ADC PARKS & GREENSPACE ARBORICULTURE CONSULTATION

PLANNING APPLICATION Ref: AW/320/11/T 1 Lichfield Gardens Aldwick PO21 3RB

BRIEF DESCRIPTION: Crown lift 1no. Scots Pine by 5 metres, crown thin by 5% & remove deadwood. Crown lift 2no. Corsican Pines to 5 metres, crown thin by 5% & remove deadwood.

T-1717, T-1718, T-1719 Aldwick Area 3

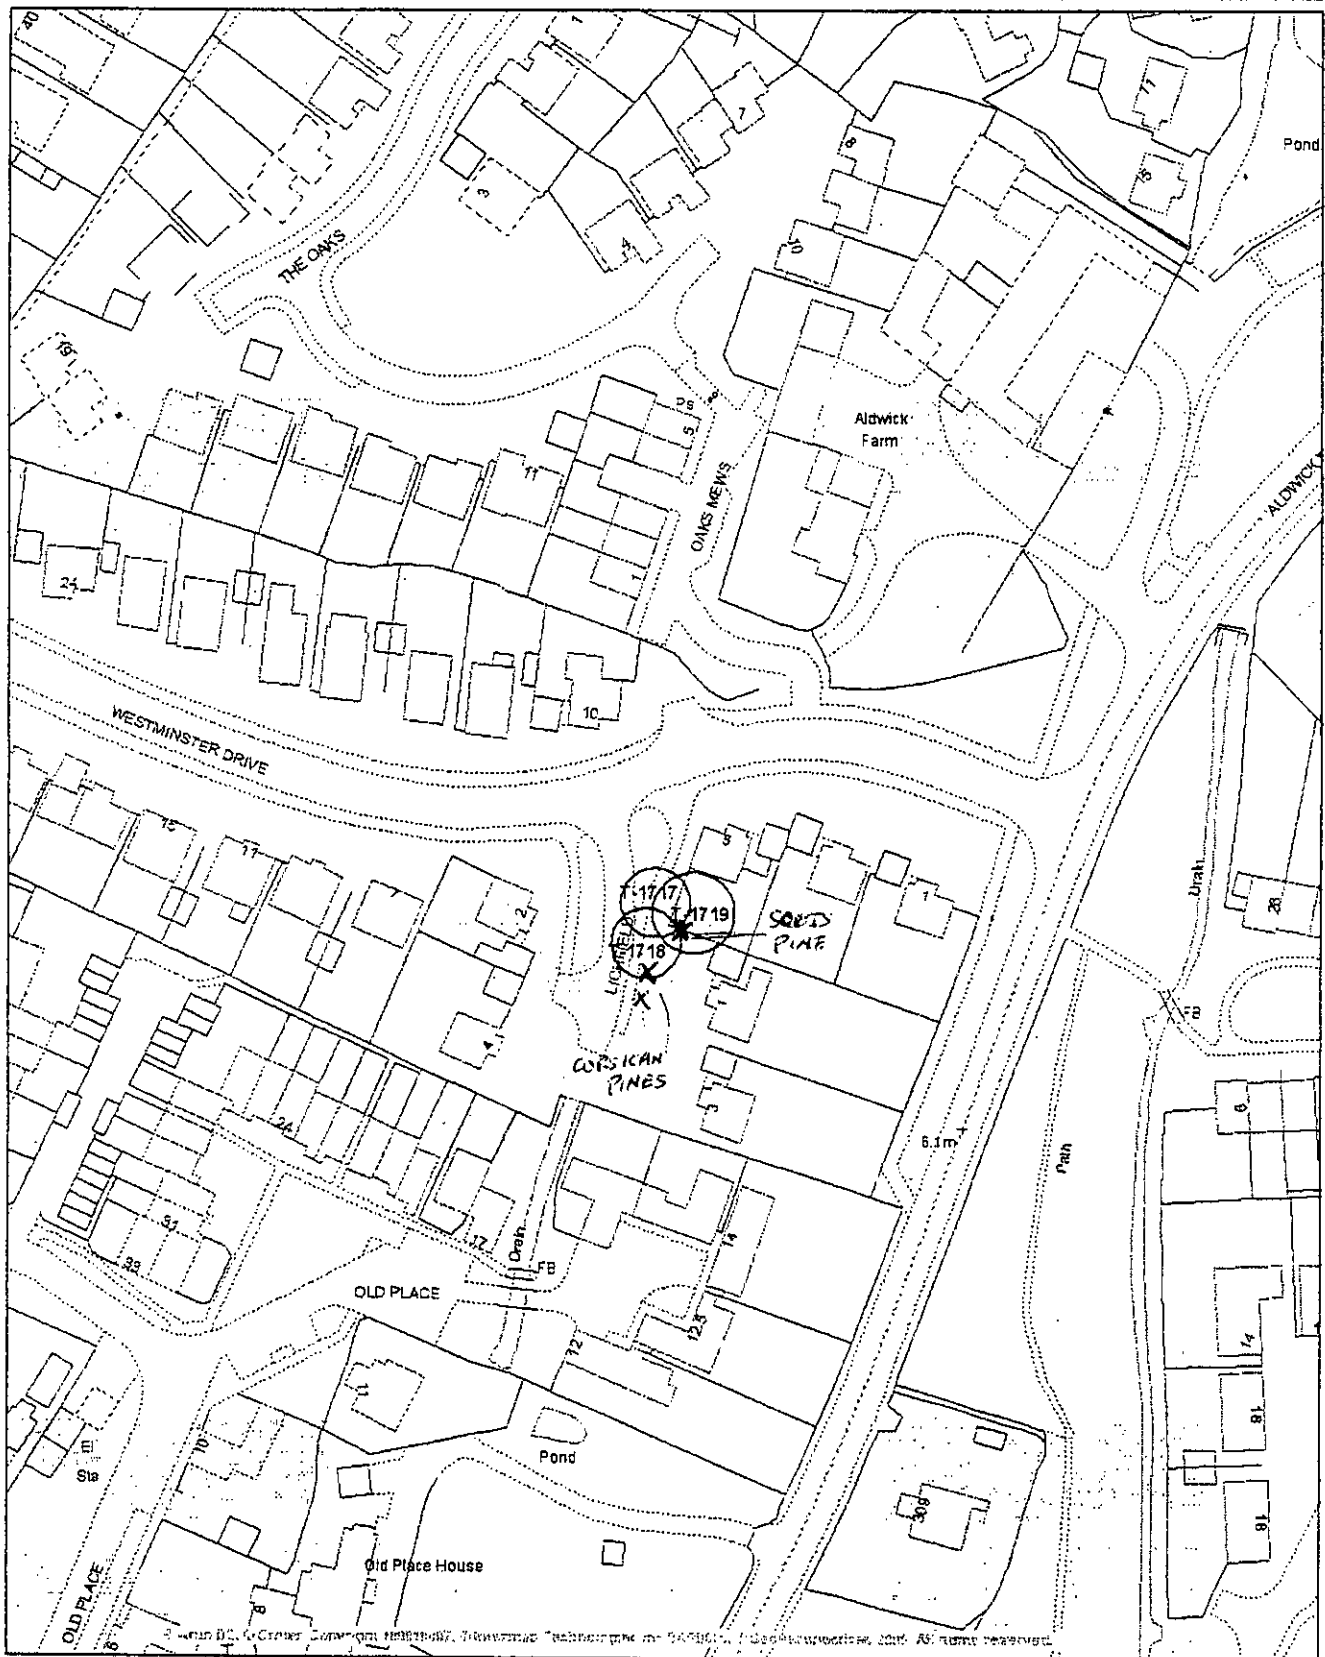
The applicant requests the pruning of three pine trees, a Scots Pine and two Corsican Pine. The applicant appears not to have provided a reason for the tree works. However it is clear that the work is for practical reasons i.e.; to remove obstruction from the highway and alleviate shade from the conservatory. The proposal is acceptable and should be in accordance with the suggested conditions, below;

Both Pine trees indicated within the application for crown thinning should not exceed the loss of 5% of their total leaf-bearing twig structure. The majority of material to remove as part of the crown thin should consist of deadwood, stubs and damaged and weak growths. An even density of foliage, with a well-spaced and balanced branch structure and framework should be achieved after the crown thin.

The crown of the Corsican Pine tree overhanging the conservatory should be pruned to provide a vertical clearance above ground level to a height of 5m. The other Corsican and Scots Pine trees should be pruned to provide a vertical clearance above ground level to a height of 5m. Branches found within the clearance height having diameters greater than 100mm should be shortened and no more than 15% of the leaf bearing growth of those branches should be removed.
